SM ROCHA, LLC

May 7, 2025

RE: Retreat at PrairieRidge Filing 1 / Transportation Memorandum
El Paso County, Colorado
PCD File No. 257

ROUND-ABOUT DESIGN BASED ON:
"ROUNDBOUTS - AN INFORMATIONAL GUIDE"
US DEPT. OF TRANSPORTATION FEDERAL
HIGHWAY ADMINISTRATION PUBLICATION NO.
FHWA-RD-00-067, DATED JUNE 2000

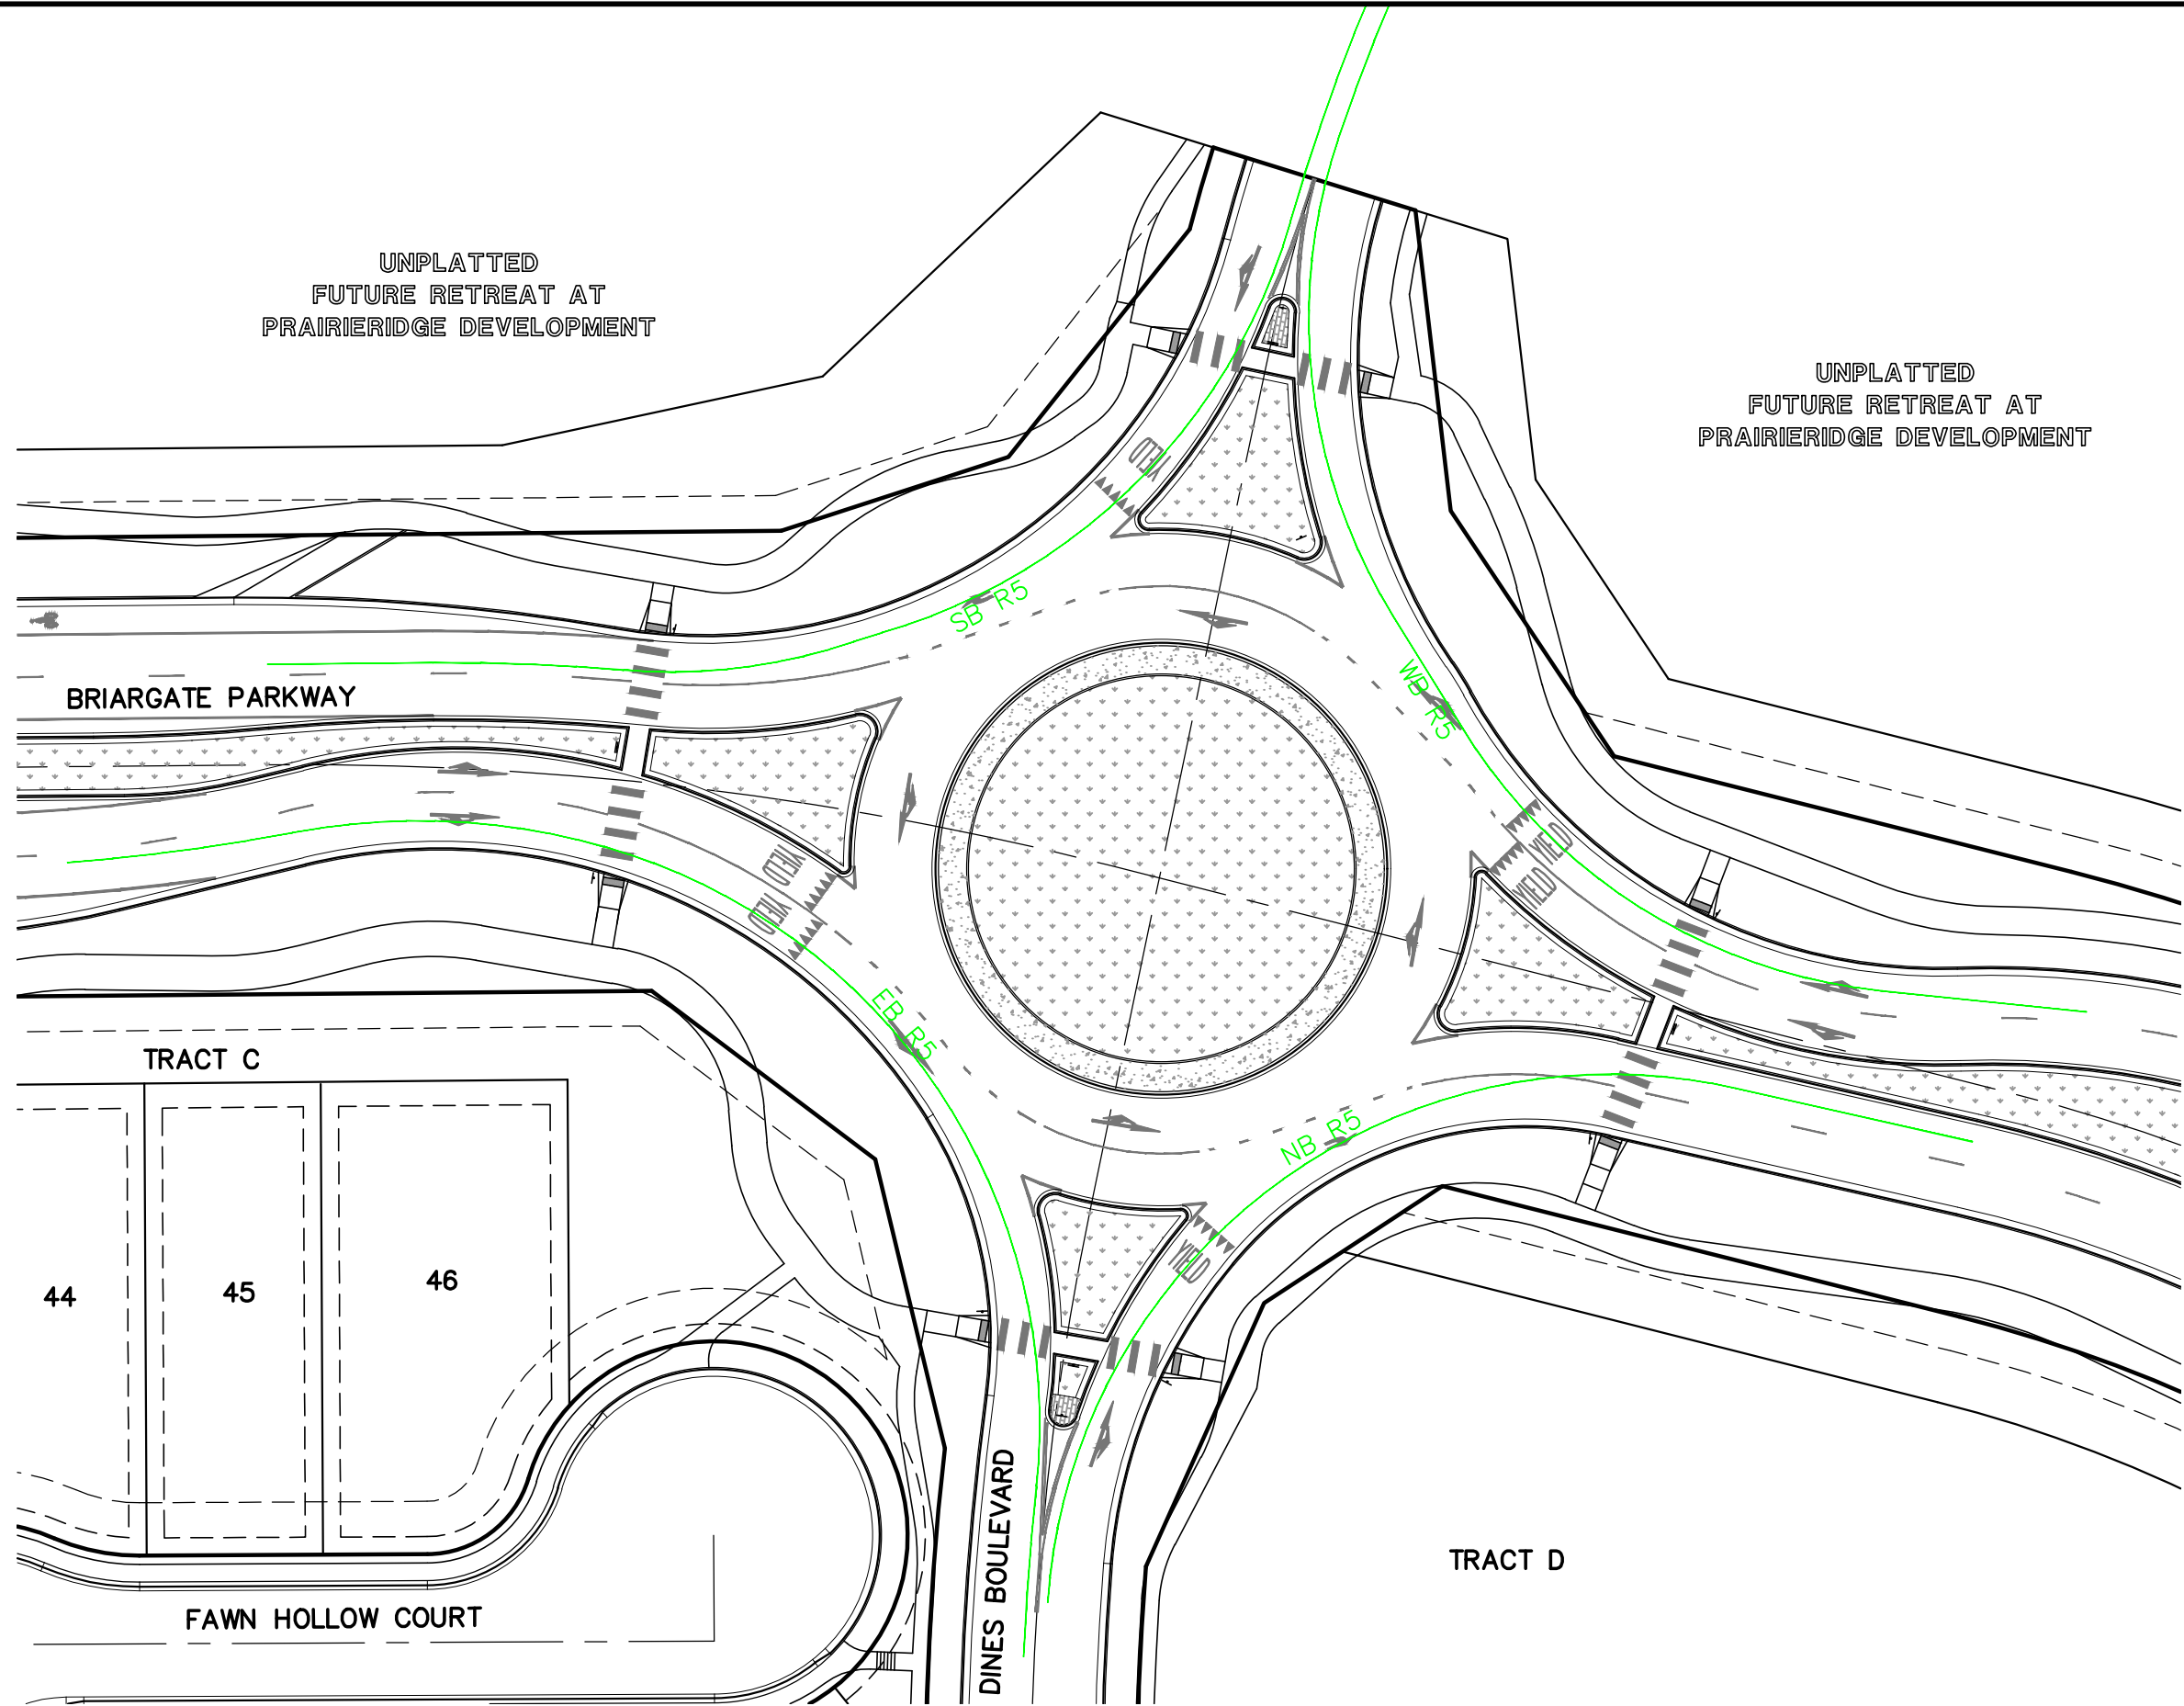
The future Briargate Parkway intersection with Dines Boulevard is recommended to operate under roundabout control. This recommendation is consistent with analyses provided within the Retreat at PrairieRidge Filings 1-3 Preliminary Plan & Rezones traffic study and the Jayne's Property – Roundabout Consideration memorandum⁷ previously prepared for the Briargate Parkway and Dines Boulevard intersection. [Unresolved: Please provide final roundabout design report, as mentioned in the preliminary plan TIS.](#)
